**RE: Triview Metropolitan District
Northern Delivery System – Booster Pump Station
Site Development Plan – Comment Response Letter
PPR-2262**

Below are responses to comments provided 11/30/22 – 01/20/23 for agency review of the above-referenced project. We have inserted our responses and actions taken in **blue** below each comment.

**C2**  
 SHEET --- OF ---

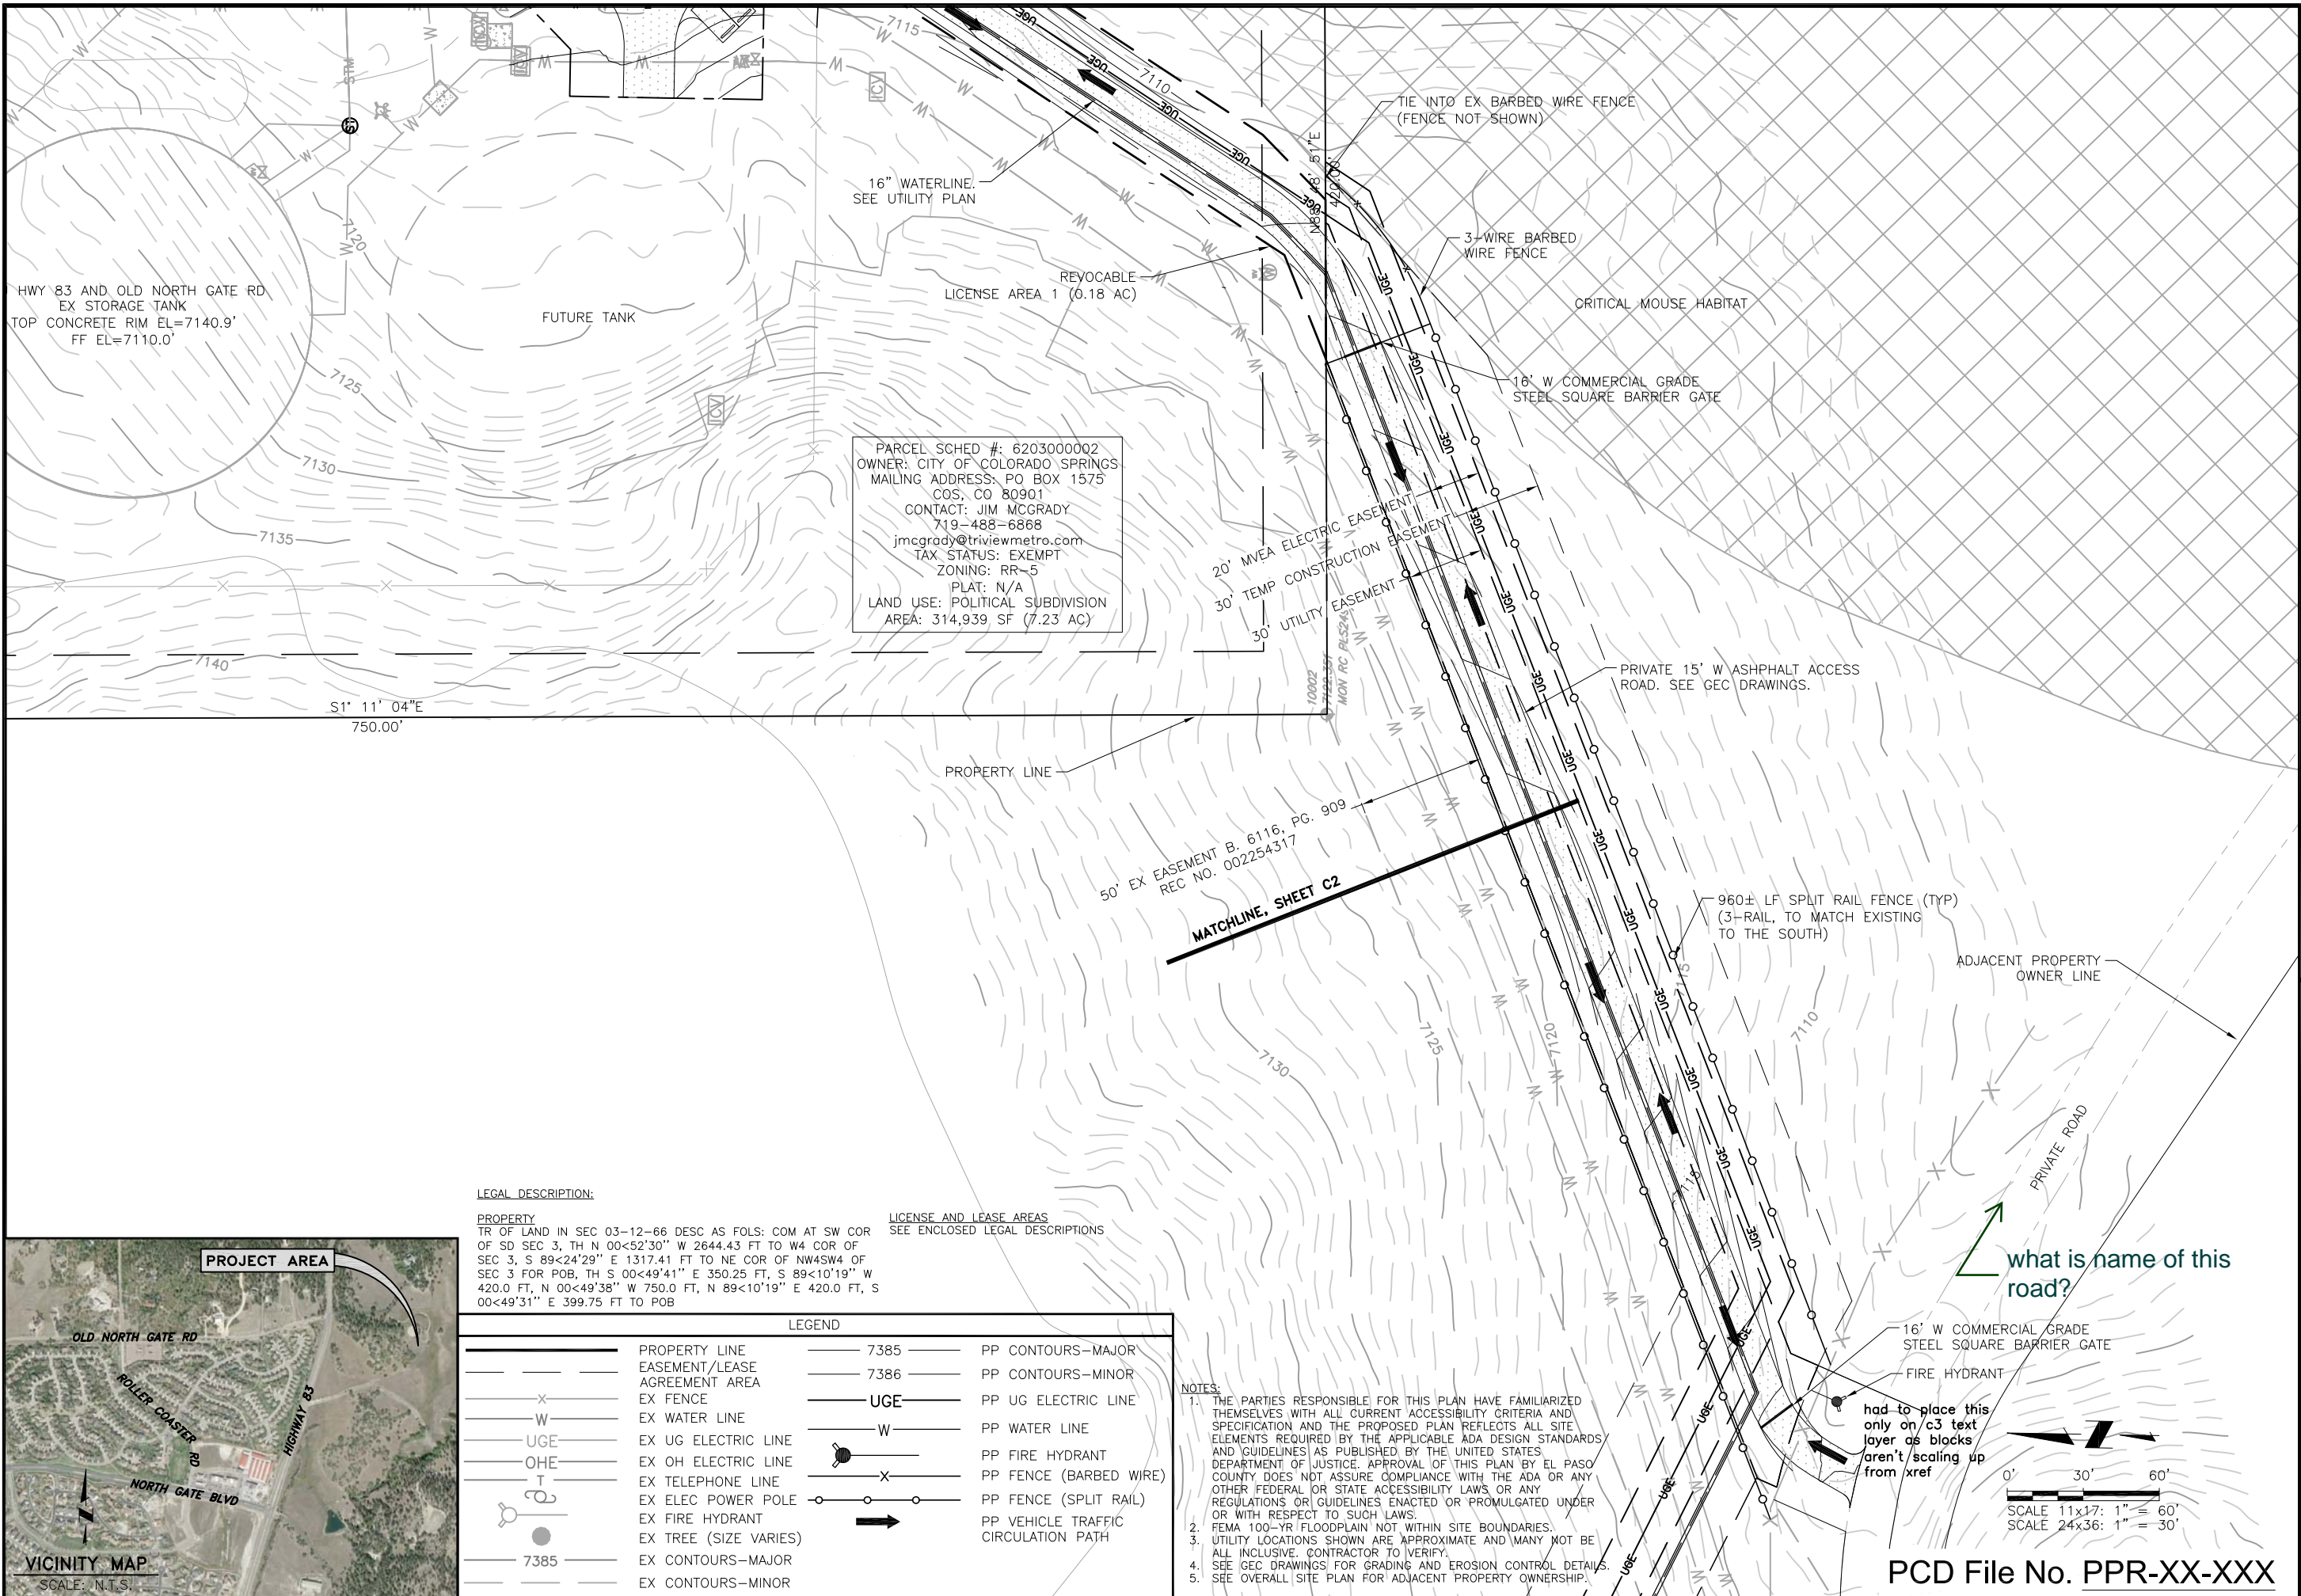
1.2 Dimension building from property lines; label 25' building setbacks line and depict lines

1.4 Dimension building from property lines; label 25' building setbacks line and depict lines

Dimensions and setbacks already previously shown on Sheet C2 and are intentionally omitted from Sheet C1 for readability. See Sheet C2.

Building dimensions from property line added and building setbacks already depicted, see Sheet C2.

A3
SHEET 31 OF 54

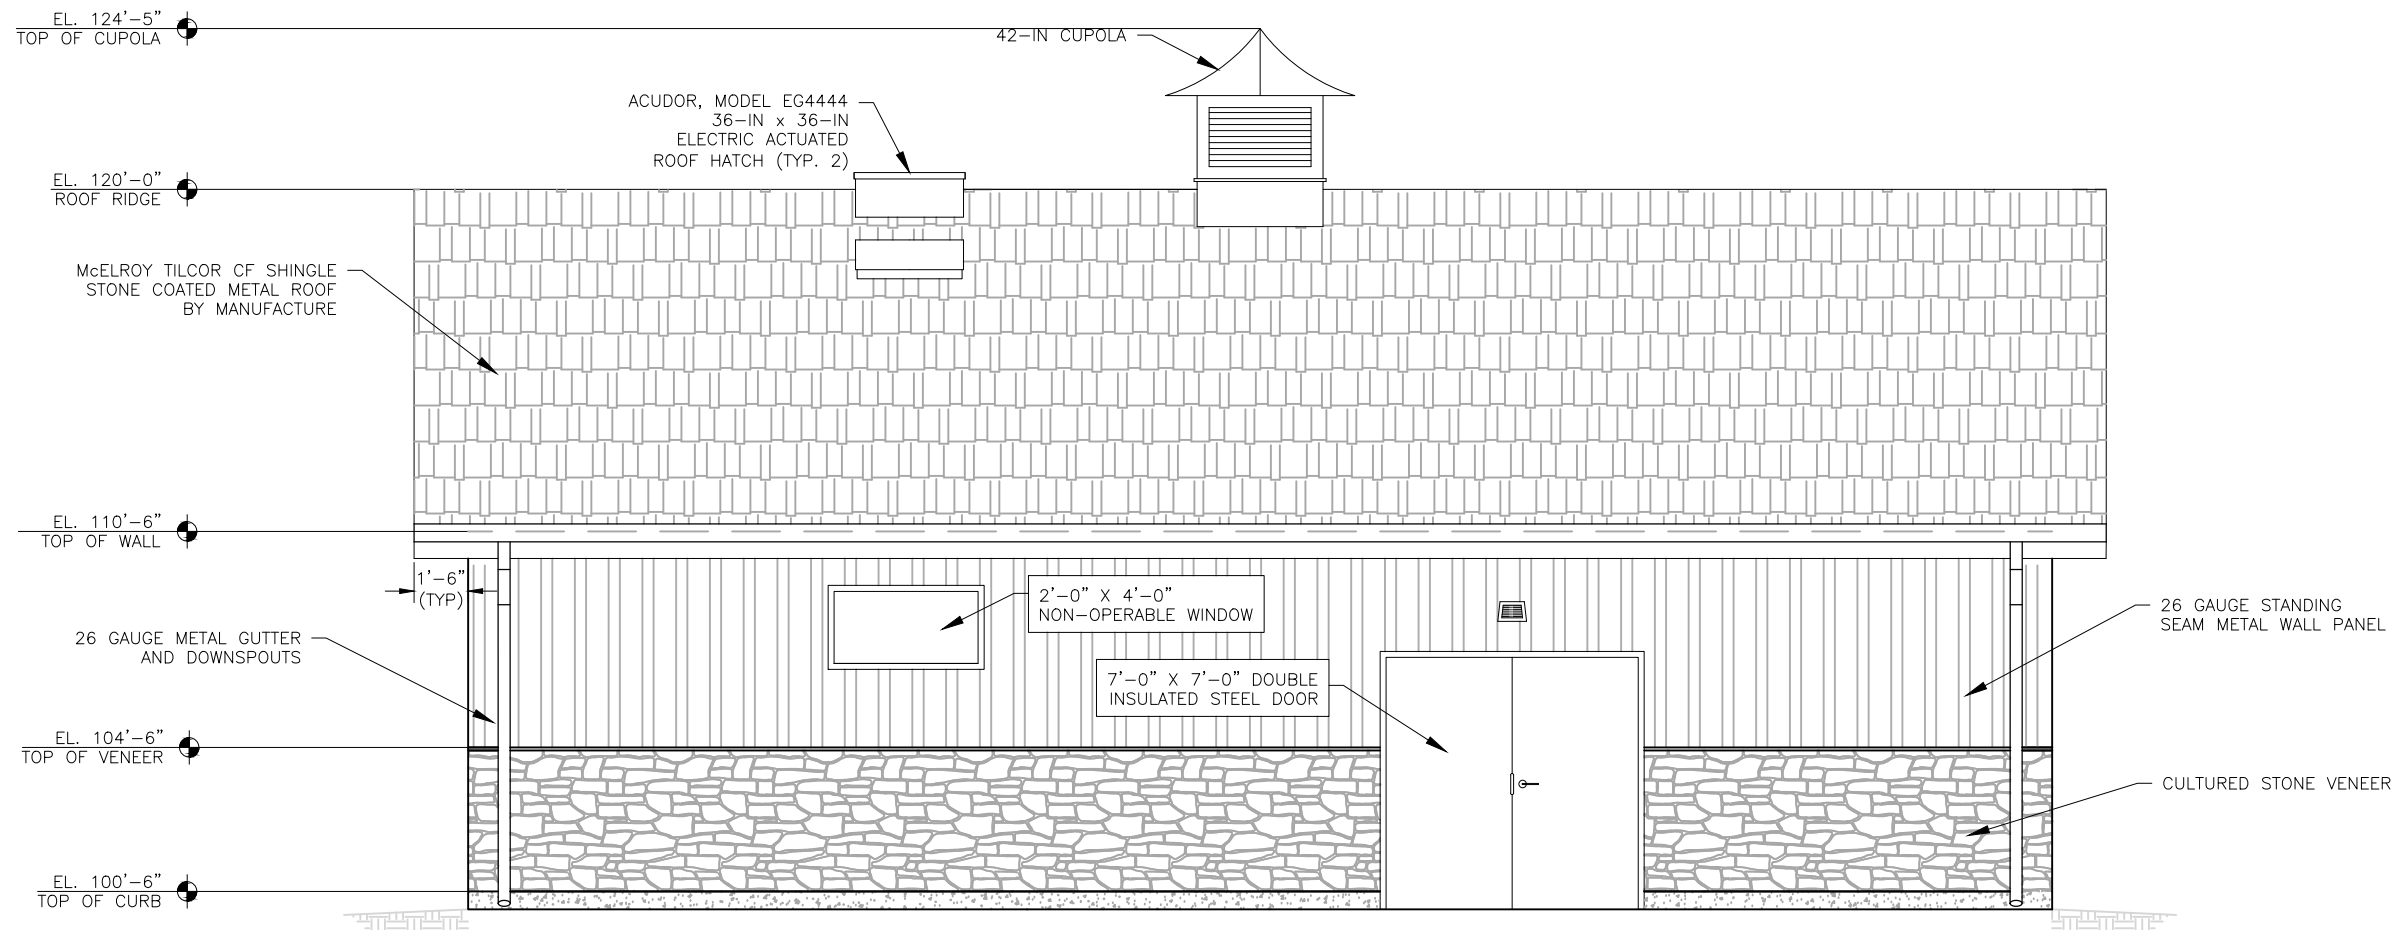
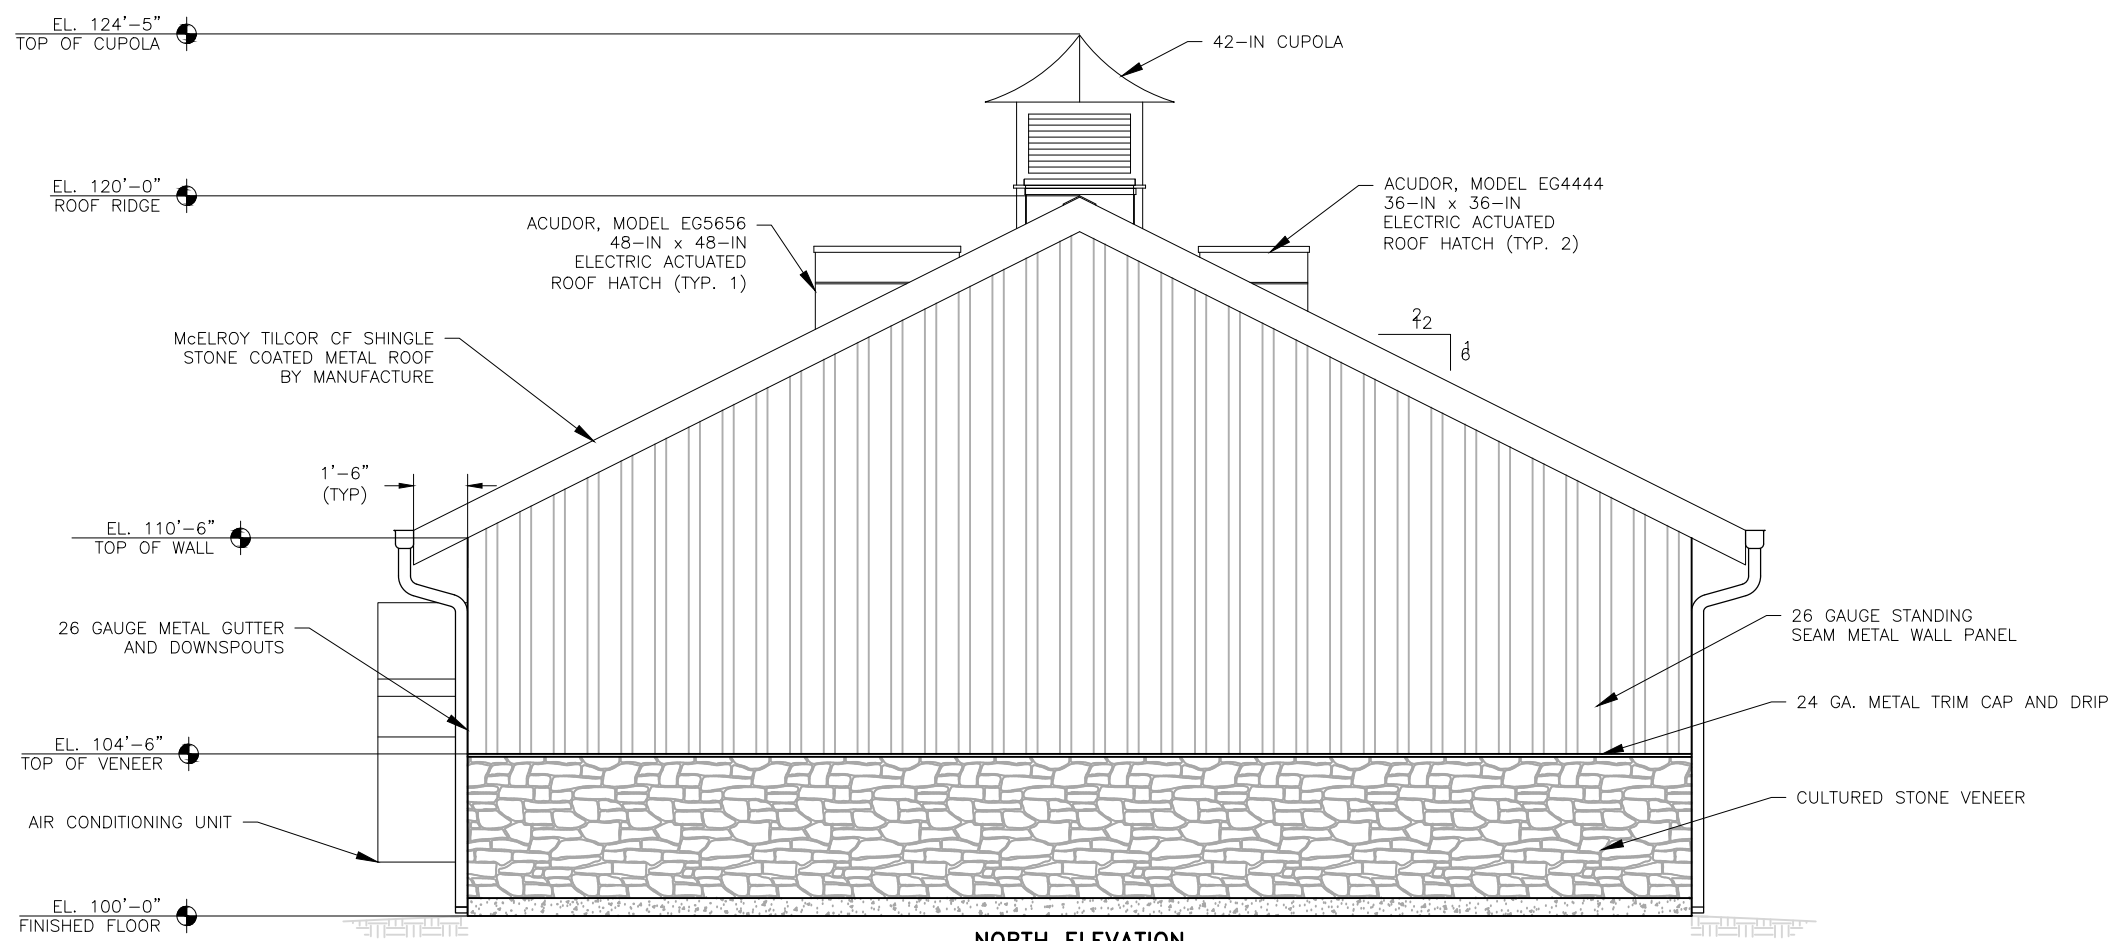
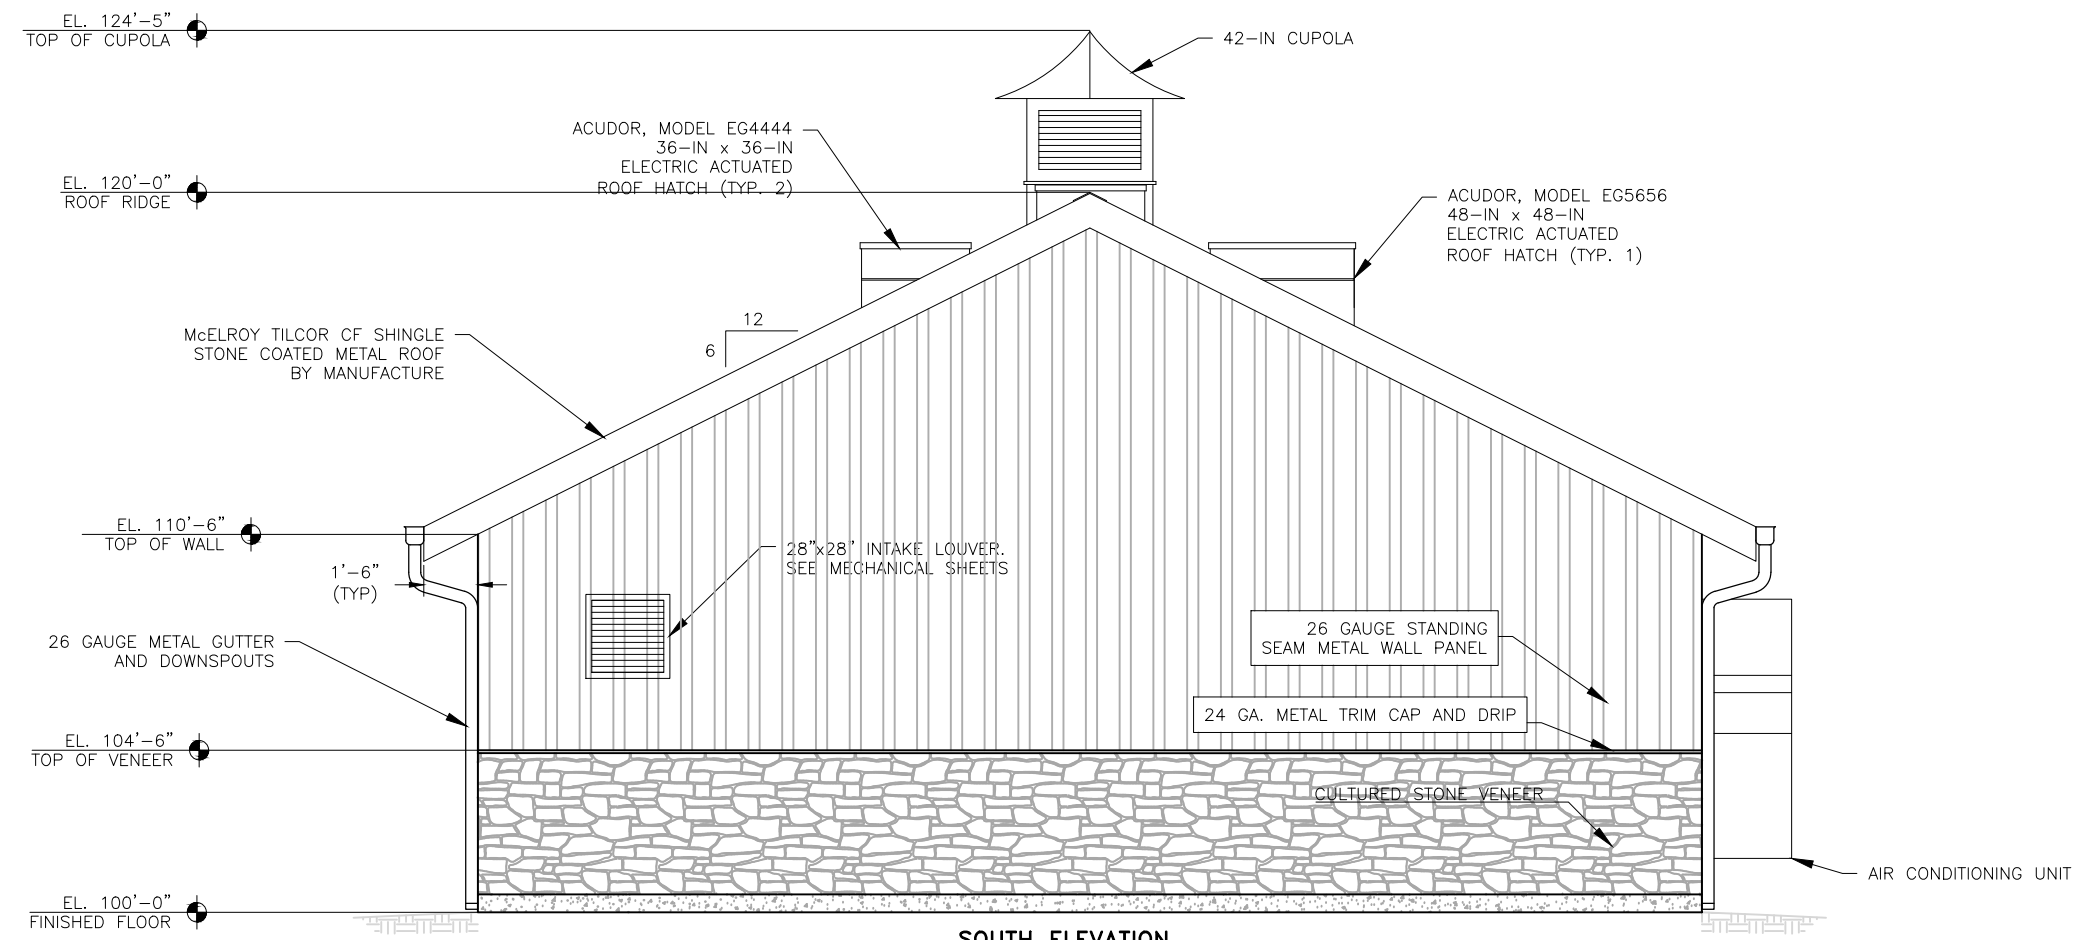
Please additionally note Architectural Elevation sheets are being included with this resubmittal, as updates to the building's roof type have been reflected.
